**Cherwell District Council: Northwest Bicester Eco-town – Exemplar Site
Planning application reference: 10/01780/HYBRID**

Thank you for coming to the meeting of CABE's design review panel, chaired by Sunand Prasad, on the 26 January 2011 in connection with this scheme. Following a site visit and a meeting with the design team and local authority, and a previous review, we are pleased to comment on the scheme in light of the presentation and the discussion which followed it. CABE's views, which supersede all views which may have been expressed previously, are set out below. This is our formal response to the planning application.

5.14 Appearance: Housing Design and Architectural Language

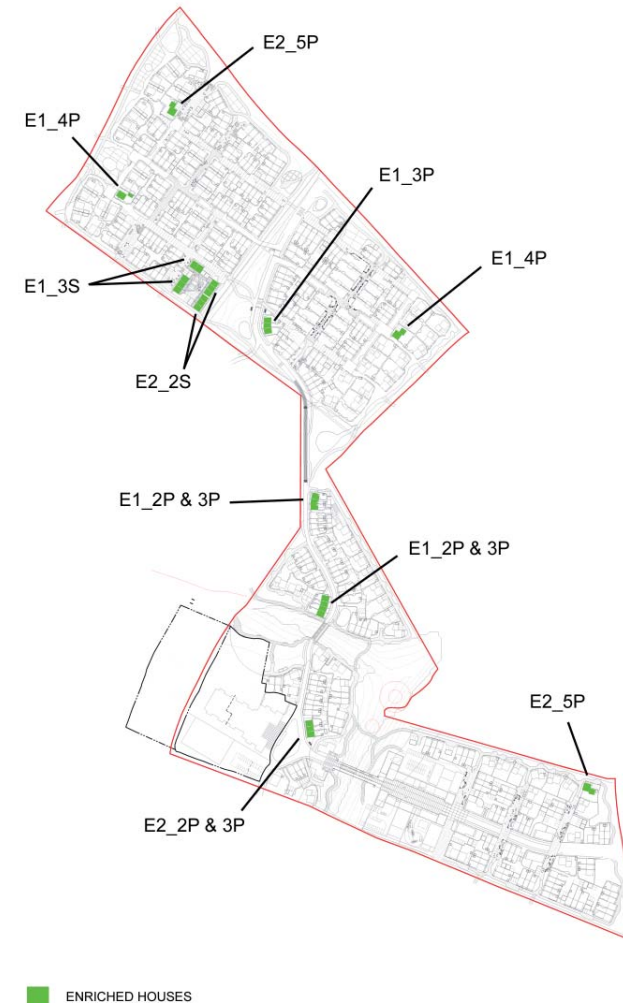
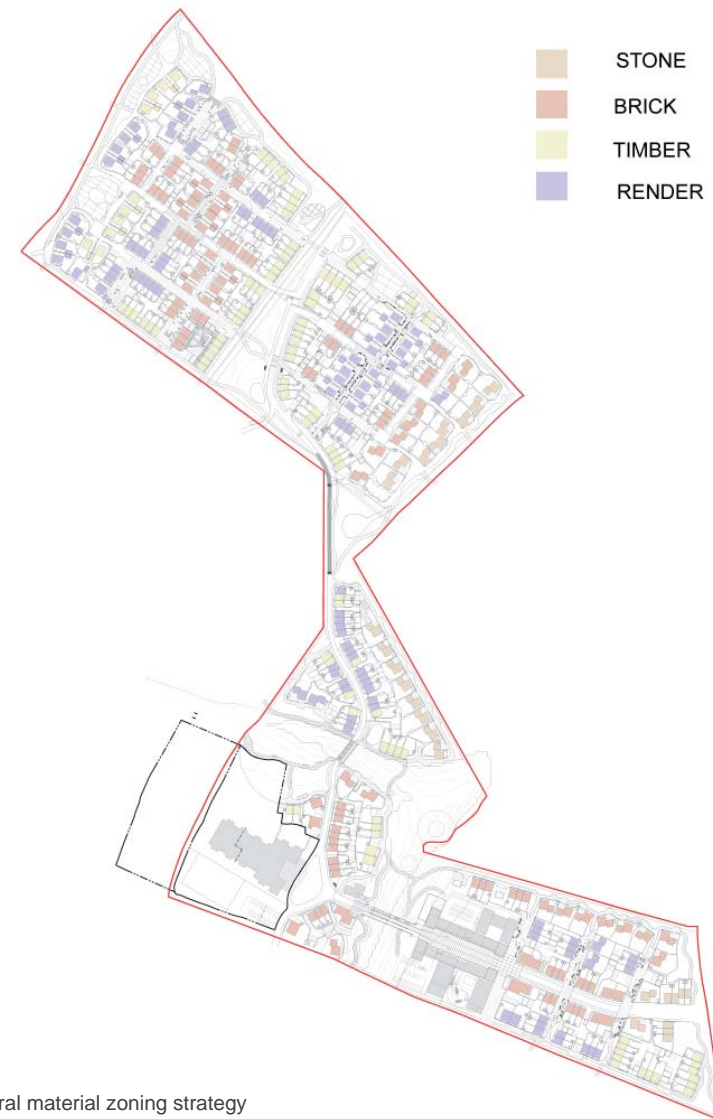
We are encouraged to see that three different architects are working on the housing designs, but are disappointed that a greater variety of house types is not emerging to provide a greater choice for buyers. All the clusters of development are the same in terms of building typologies and architecture, and that there is limited variety in terms of the size of dwellings.
